Director Infrastructure Projects
Department of Planning and Environment
Major Projects Assessment
GPO Box 39
SYDNEY NSW 2001

PROPOSED NORTHCONNEX M1 / M2 TUNNEL PROJECT - Application Number - SSI 13_6136
We object to many aspects of this project

MOTORWAY OPERATIONS COMPLEX - SOUTHERN VENTILATION FACILITY - SECTIONS
M1-M2-5000-DR-JD-0525

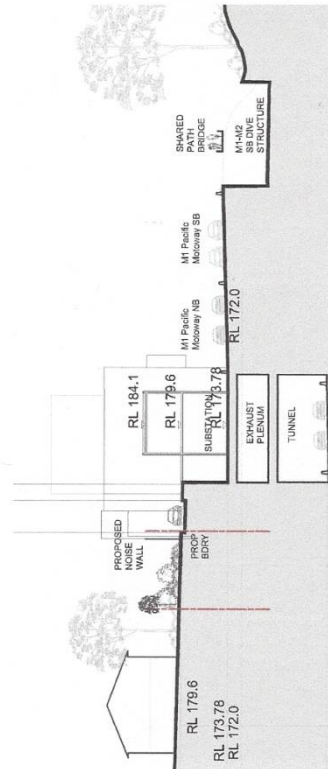
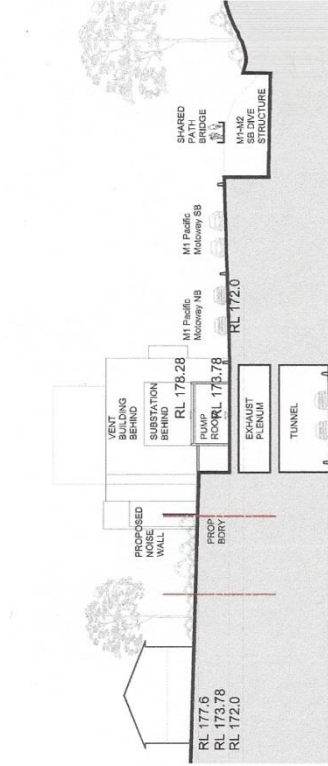
1. The Environmental Impact Statement (EIS) does not show any connection between the ventilation stack and the southbound tunnel which is 250 metres away. Will the polluted air be allowed to flow like an invisible sewer through West Pennant Hills, North Rocks, Carlingford and Beecroft?
ACTION: Provision of diagrams and detailed description of what ventilation is proposed for the southbound tunnel at the Southern Interchange. We would like the opportunity to lodge further submissions once that has been provided.

2. The ventilation stack should be located immediately above the tunnels on the corner of the Pennant Hills Golf Course and the M2. NorthConnex admit that this is the most efficient location for the stack. Why is the stack not being correctly located and positioned as far as possible away from homes?
ACTION: Purchase of golf course land to position the stack in its most effective location.
